20150617.1/0302A/R0/TT

03/02/2016

Business Hub, Fifteenth Ave, West Hoxton - Response to EPA Queries

We have been asked to respond to comments provided by the EPA in their letter of 27 November 2015 with respect to our acoustic assessment of the above site (*Operational Noise Impact Assessment* – dated 1.7.2015, Rev 2).

Badgerys Creek (Weather Removed From Calc): Friday 22 May, 2015

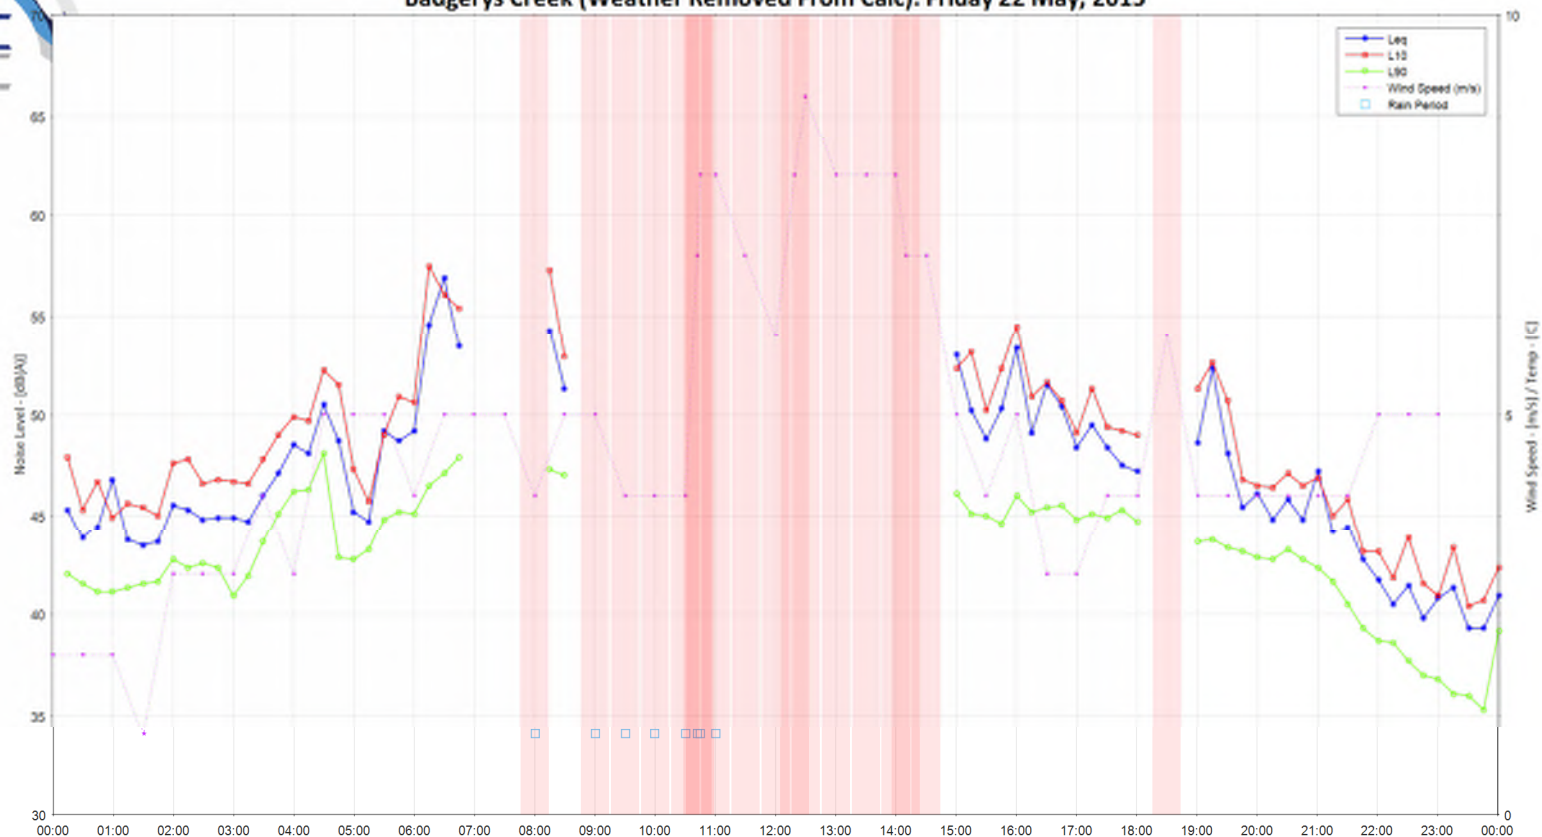
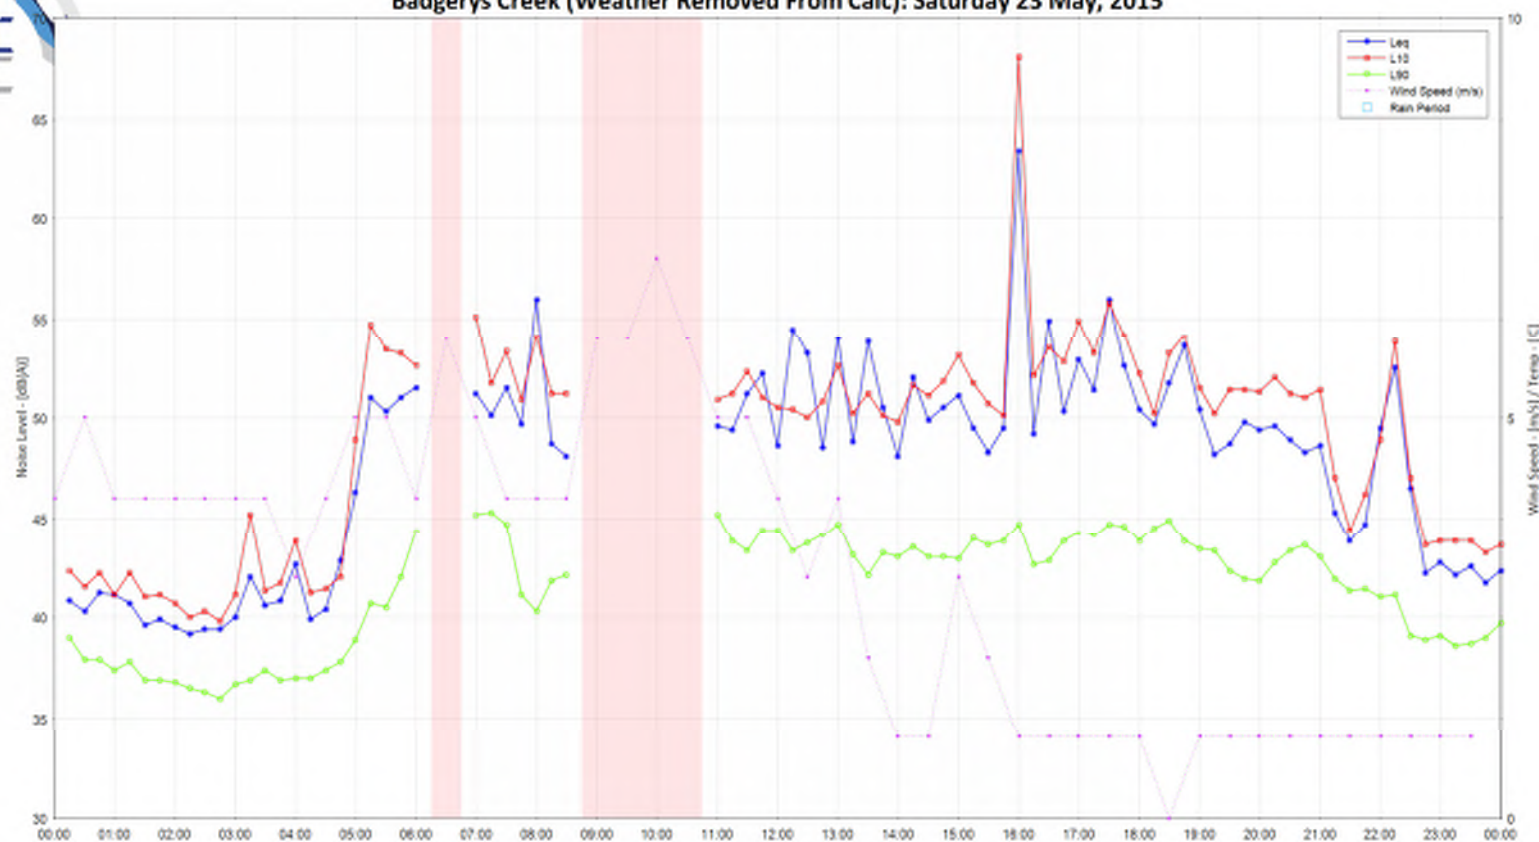
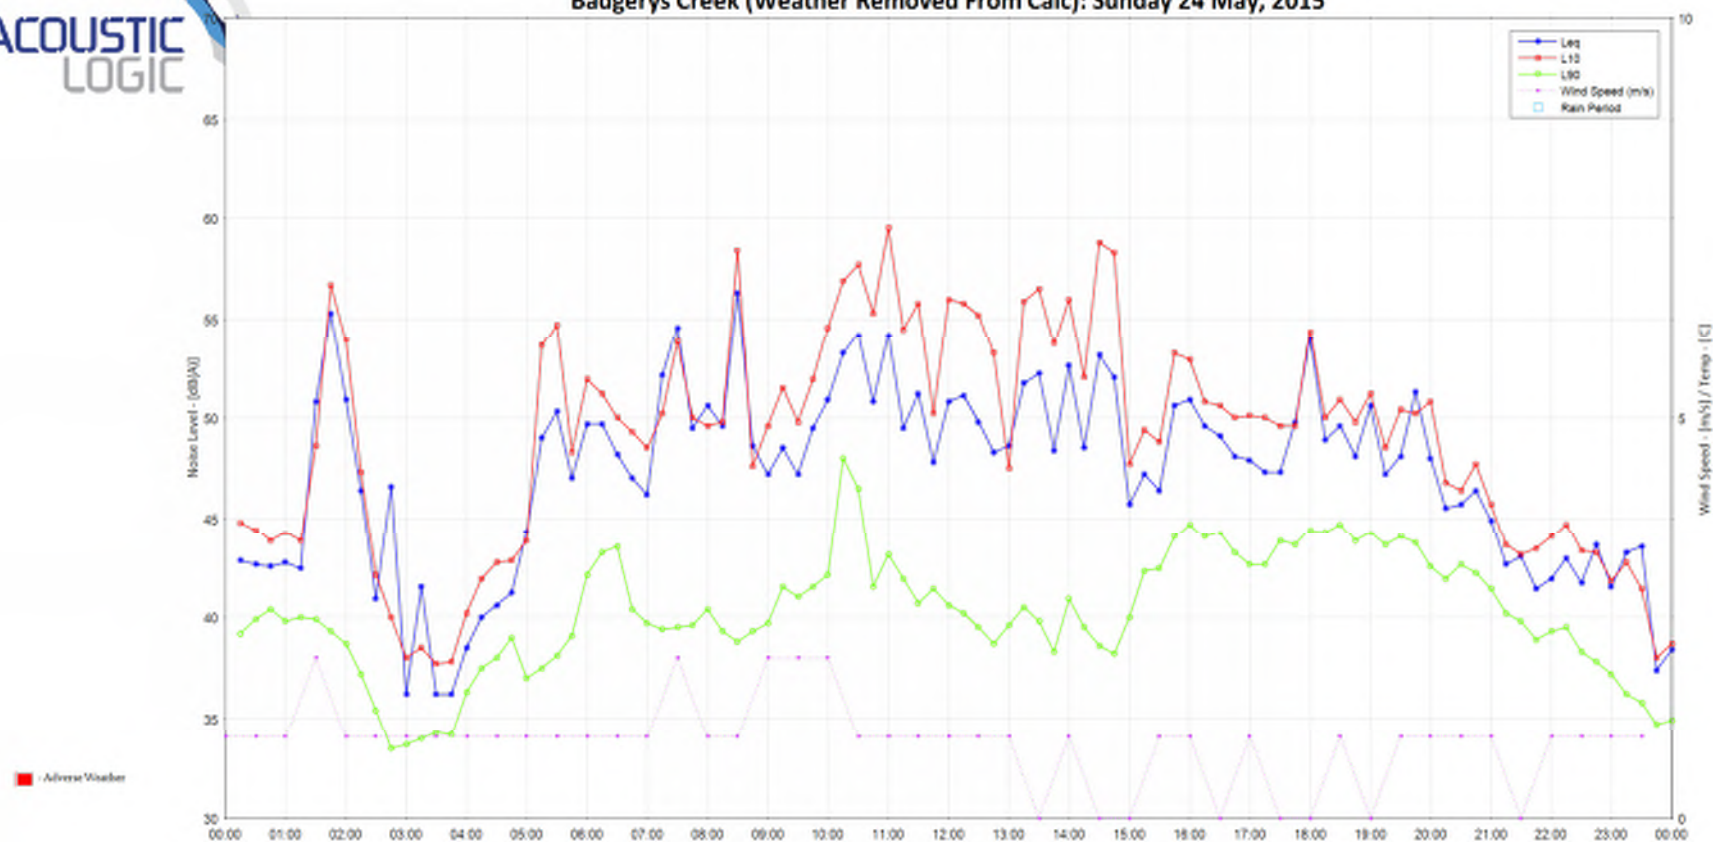
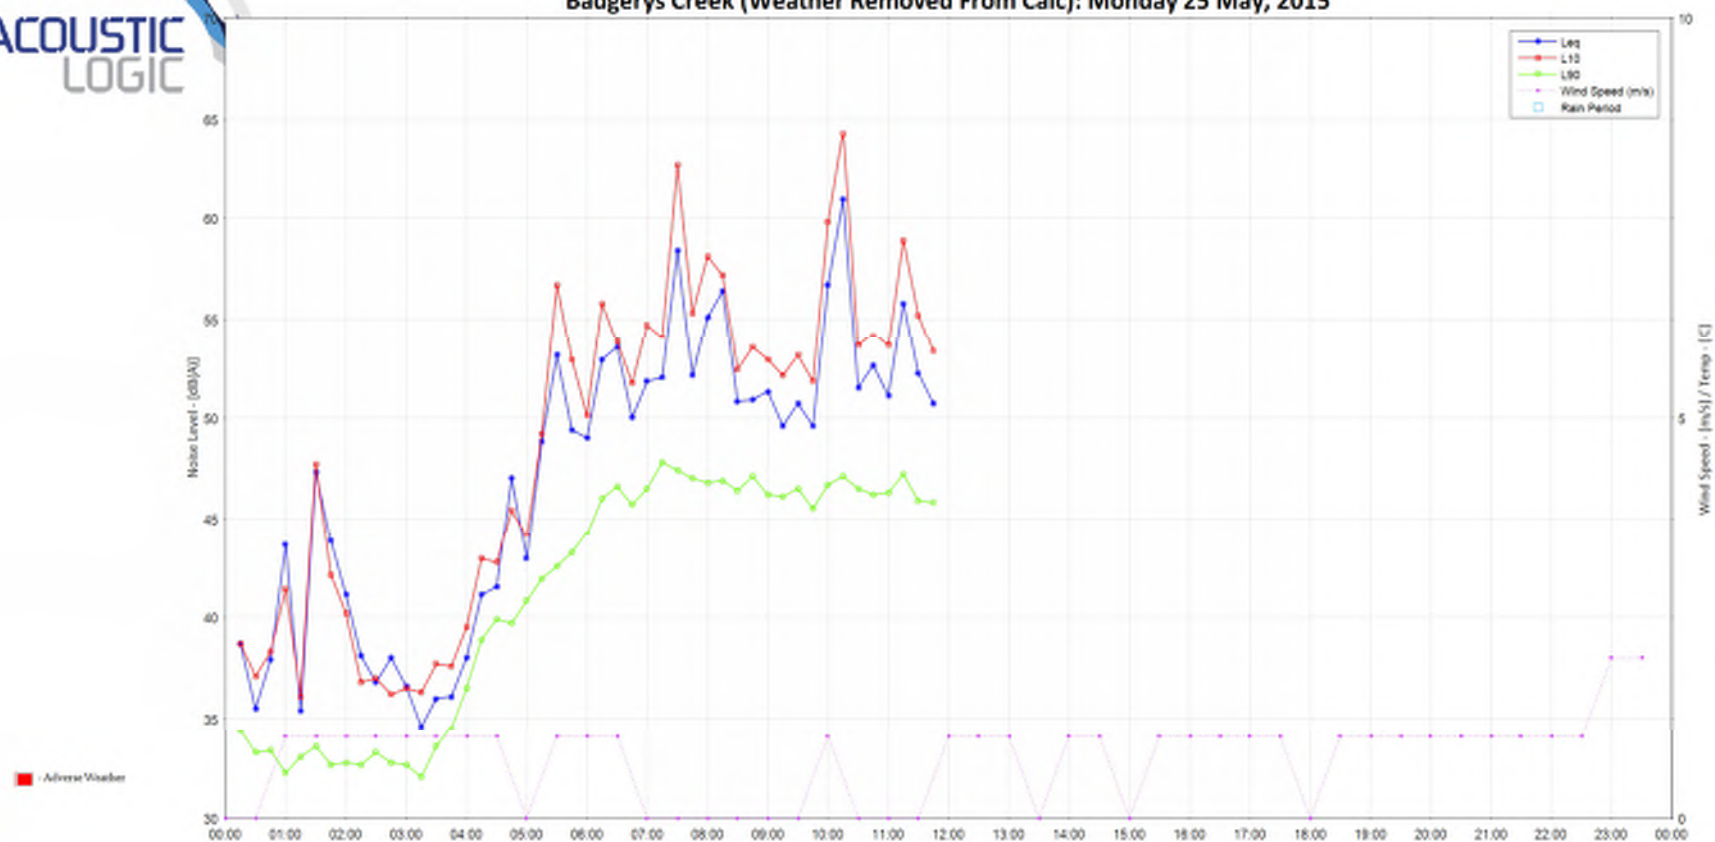
- The fact that metrological data used by them is different to that used by ALC in determining background noise levels in our report.
- The EPA has referred to a number of “wind gusts” which should have resulted in that periods of noise logging being omitted when determining background noise levels.
- The EPA has concluded that due to the fact that there are periods of the logging which are weather effected, that the logging should be re-done.

- With respect to the EPA reference to wind gusts exceeding 18 kilometers per hour on each day from 18 to 23 May, this is in fact irrelevant. Section 3.4 of the Industrial Noise Policy refers to *average* wind speeds for entire 15 minute periods as being the criteria for determining whether that period of data is to be excluded. A short duration wind gust is not relevant, only the average wind speed is. It is the *average* wind speed which was used by ALC in determining Rating Background Noise Levels, which is consistent with EPA practice.

- As a precaution, background noise levels were determined using both the Badgery’s Creek and the Bankstown Airport weather data. The same rating background noise level was determined regardless of the weather data used. Both sets of meteorological data are included in the amended *Operational Noise Impact Assessment*.

- When viewed over an entire one week period, the duration of weather effected data is very small (only one relatively prolonged period with adverse weather occurring during the daytime on 22 May 2015). Other periods were one hour duration or less.

Noise logging data was processed in accordance with EPA guidelines with respect to the impact of adverse weather. The weather data used for assessment was taken from a nearby weather station. Given the overall short duration of weather impacted data, the Rating Background Noise Level used for assessment is accurate.
